Planning application no. 3/2024/0465

Re the planning application from Barnacre road school, new fence, looking at the application it states the fence is 2400mm high.

Fencing at Barnacre Road School, Longridge

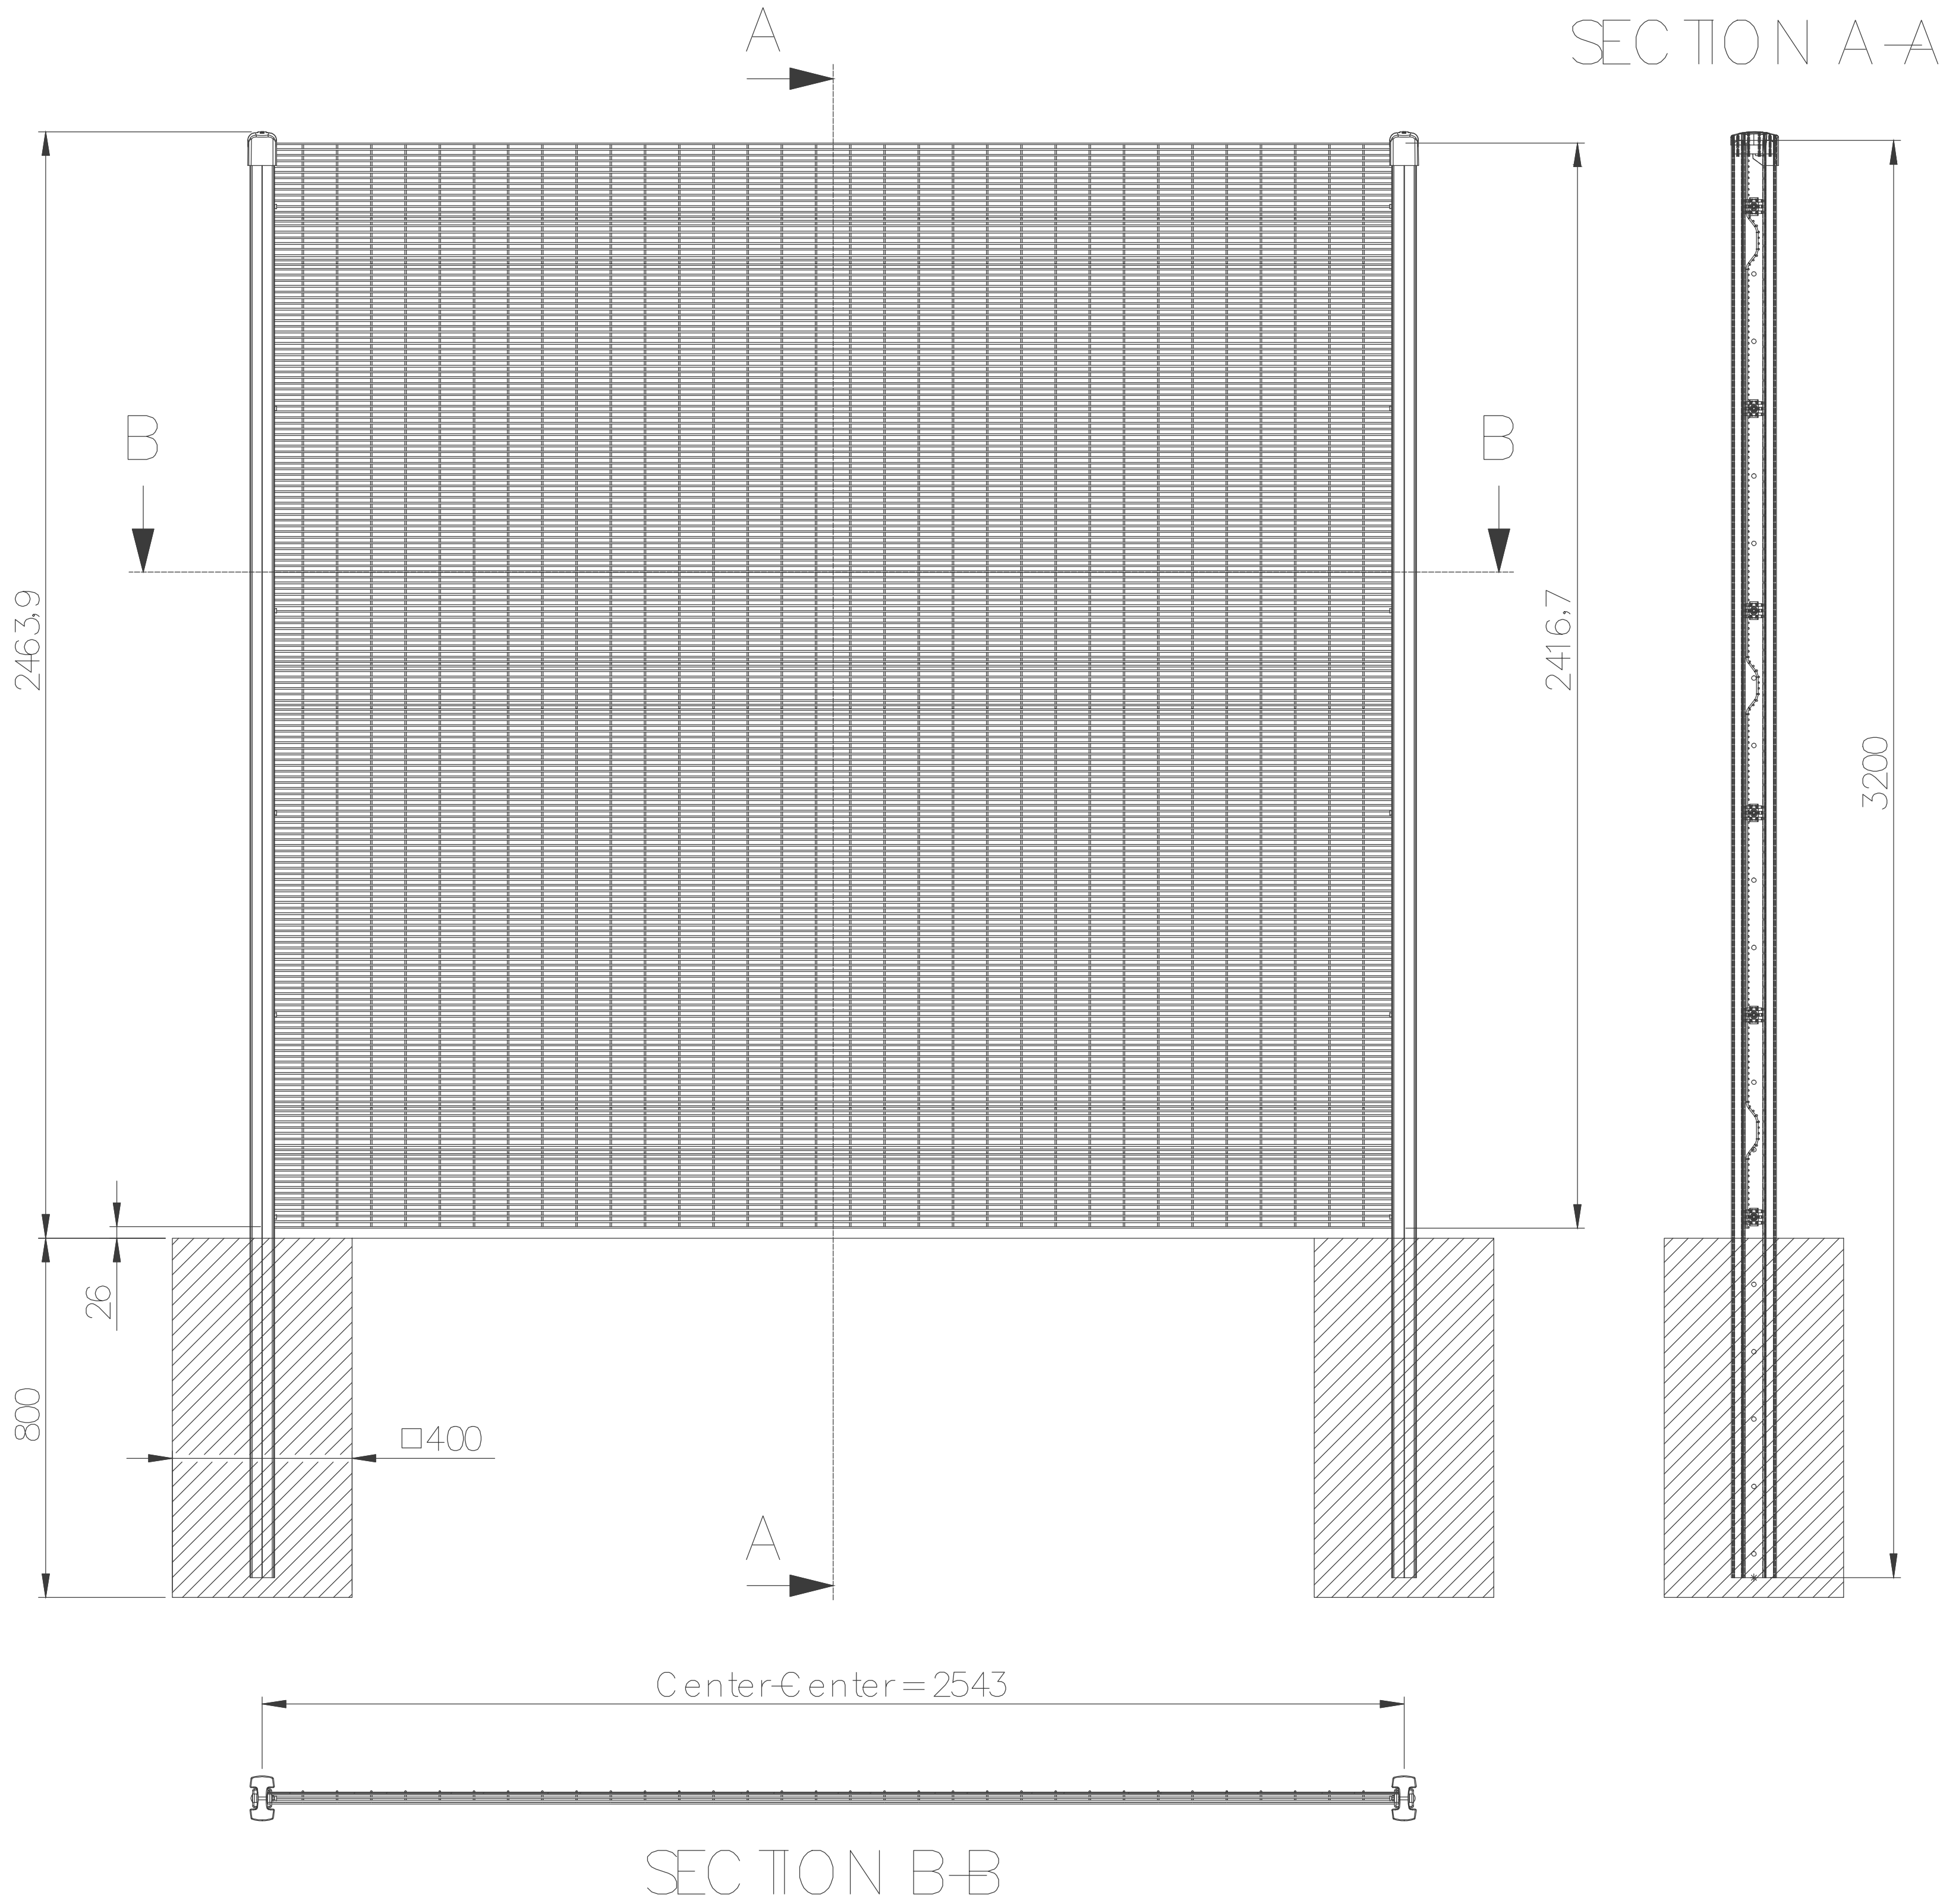
Where this backs onto existing hedges it will be higher and it will also hinder the maintenance of the beech existing hedge rows,

Could the height be reduced to a low level of 1800mm,

I am writing to you regarding the planning permission to install the 2.4metre high fence with barb wire around Barnacre road Primary School. I object to this proposal and consider it unnecessary and unsightly. I understand you may need to ensure safety of children but a more appropriate fence could be installed.

I have been informed by a neighbour that the mesh of the fencing is going to be extremely narrow and tightly together so that it will appear almost like a wall. I was not aware of this and wish to register my dismay if this is the case.

I have seen other school fencing and the mesh has been a reasonable width. Please can you ensure that it is not a dense mesh and also no higher than 1.8m. high. I realise that today is the last day for objections and I know that you have received many complaints.
